# Lane Cove Bushland & Conservation Society Inc

10<sup>th</sup> May 2019

## **Submission from the Lane Cove Bushland and Conservation Society to SSD 9741, Proposed Data Centre, 1 Sirius Road, Lane Cove West**

BULK EARTHWORKS QUANTITIES

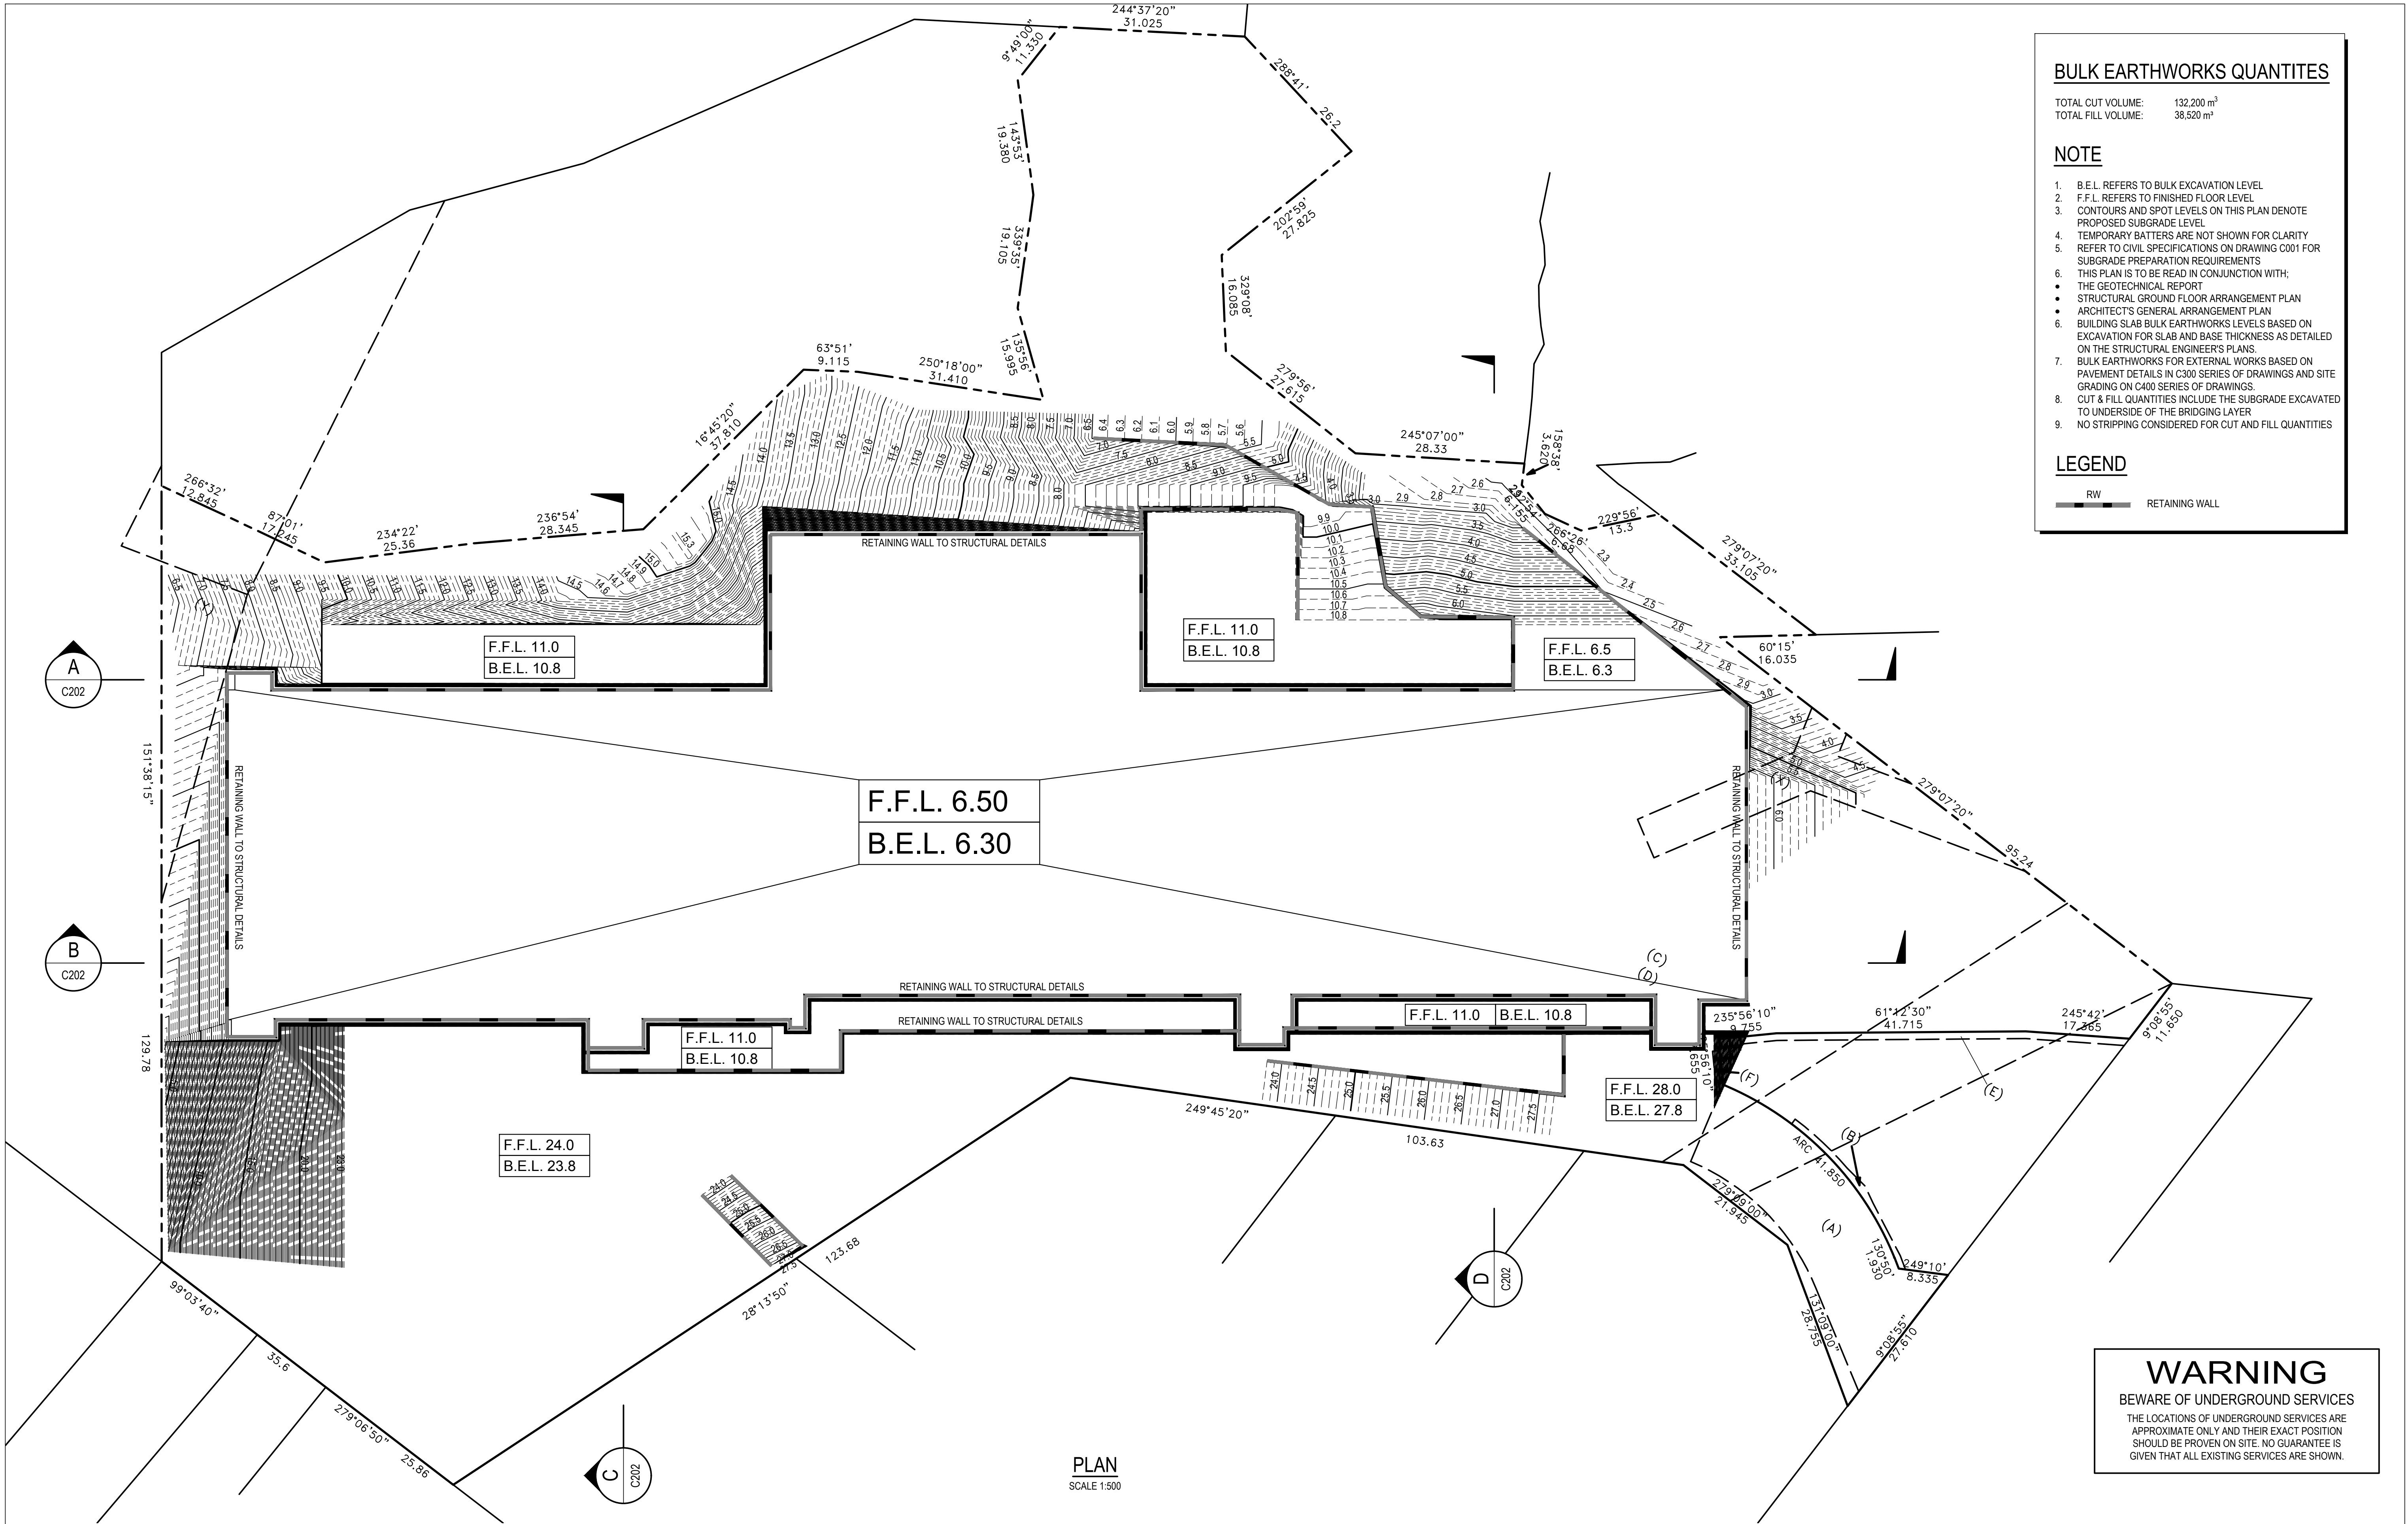
The extensive excavation and fill necessary to keep the height under the control and the levels to maintain access for servicing the equipment, mean that the site will be quite radically transformed, to the detriment of the adjoining bushland as well as the bushland on the site. As noted in the section above this will affect the subsurface water to the wetland and could cause erosion with the steepness of the fill in places.

We recommend that levels be revised to reduce the amount of fill and the steepness of any fill still required as well as raking the steps outlined above to provided surface and sub-surface water to the wetland area.

EROSION AND SEDIMENT CONTROL

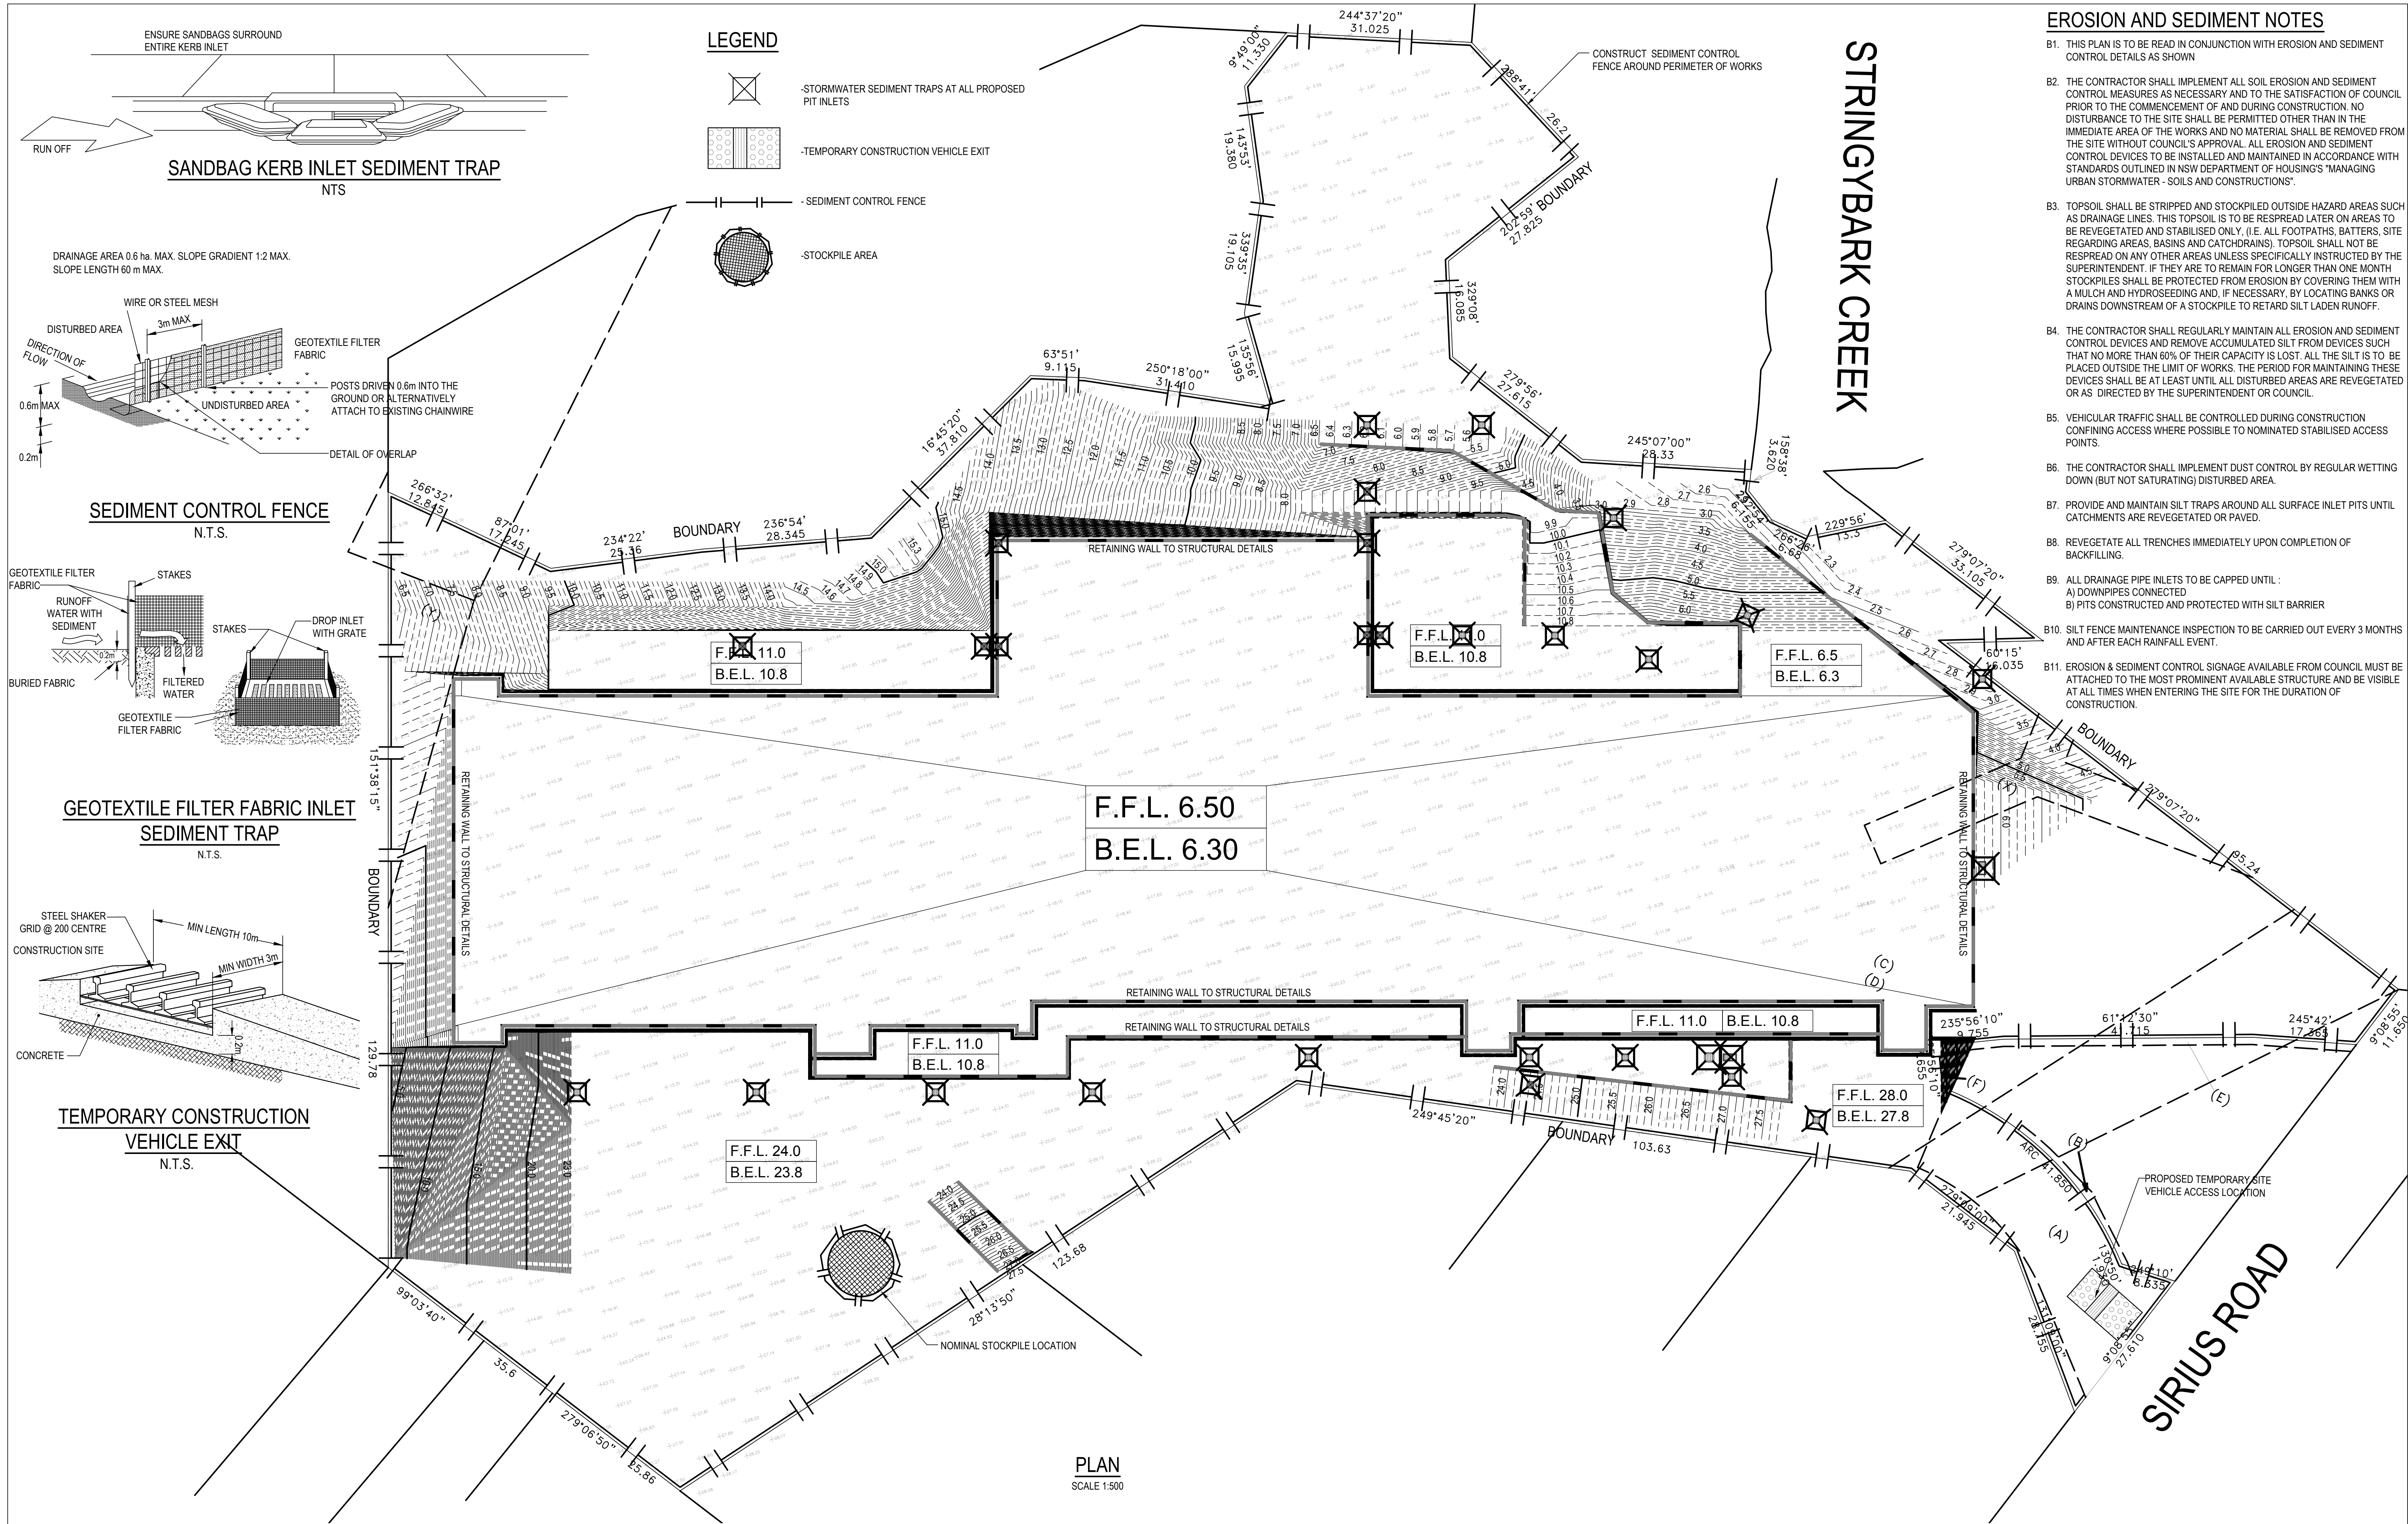
The control of sediment is vital for this site so that no debris or runoff flows into the wetland area. This has already been subject to major inundation previously and cannot afford to have any more sediment flowing into it. Any controls must be adequately monitored and regularly cleaned so that they remain effective throughout the excavation and construction periods.
